**Re: Turnbridge Mills, Quay Street, Huddersfield, HD1 6QT  
Application No 2025/65/91645/W**

notes that this application is for redevelopment of site for mixed-use, but including the demolition of buildings and re-cladding of southern elevation of retained adjoining building to the demolished Mill building; retention, conversion and renovation of the remaining existing mill/office/workshop/engine house building including alterations, and the erection of two new buildings. The buildings which form part of this application are numbered B (Hirst Mill), C, D, E, F, G and N. Of these it is proposed to retain buildings D. The most notable demolition is building B (Hirst Mill) which was only listed in 2025. It should be noted that the adjoining building to B is A and therefore demolition would affect it. Of the other buildings only D and E are considered heritage assets.

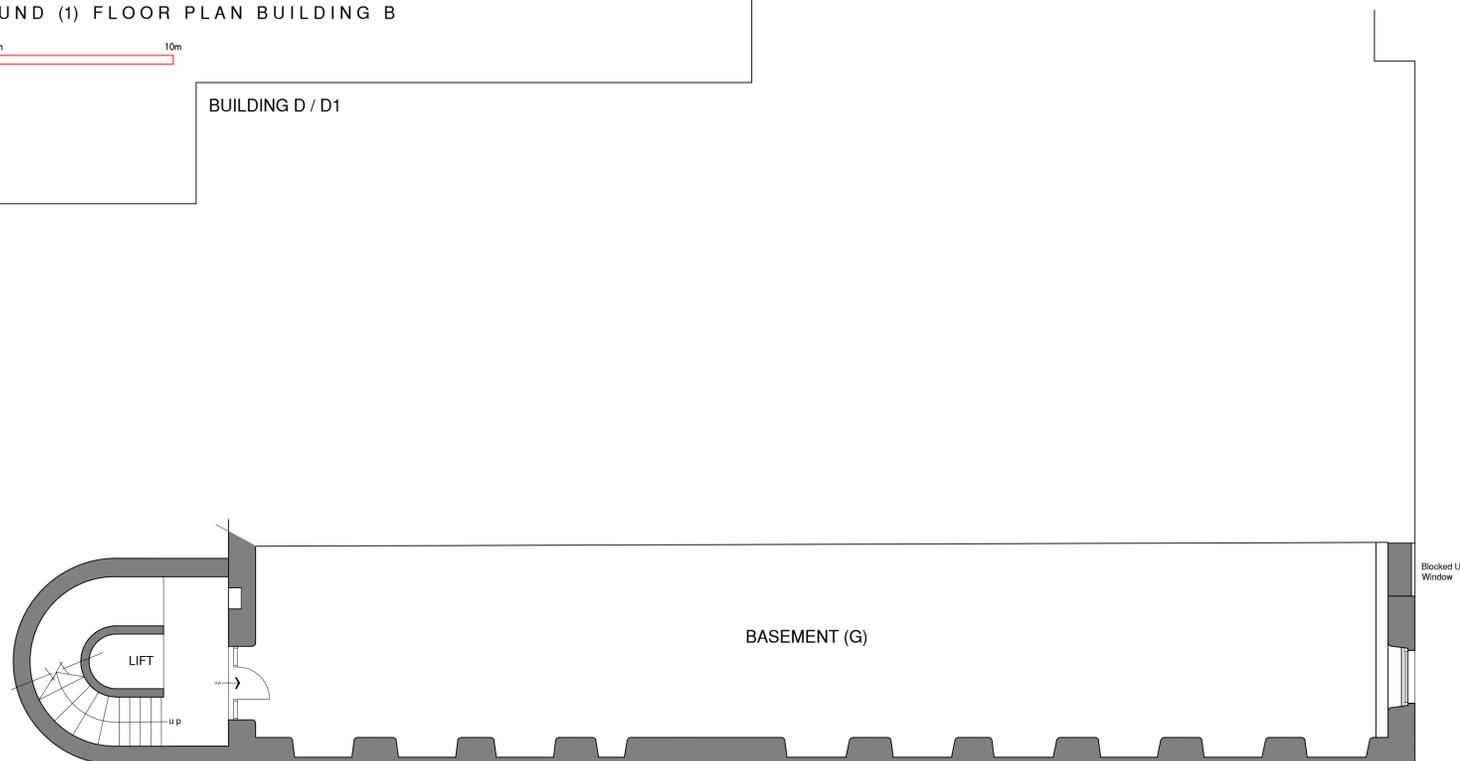
The most detrimental part of the application is the proposed demolition of Building B, a historic textile mill, for cotton spinning when built, but later (1978) for Hamel & double twisting, winding, spinning, cardroom and warehouse, although not longer in those uses. The submitted documents refer to five out of the six floors having been in use. Furthermore the Structural Report refers to the total element [of building B] being sound and operationally safe and that it exhibits only minor deterioration. The mill forms part of the group of mill buildings on this site. In particular it associated with the listed (2012) chimney. Therefore the removal of Hirst Mill (Building B) will affect the setting of the whole group, but in particular, again, the Building to which it is attached and therefore which would have to be made good if it (Building B) is removed. Whilst the loss of some of the other buildings is to be regretted, the loss of Building B would be detrimental to the whole site.

recommends that this application be refused.
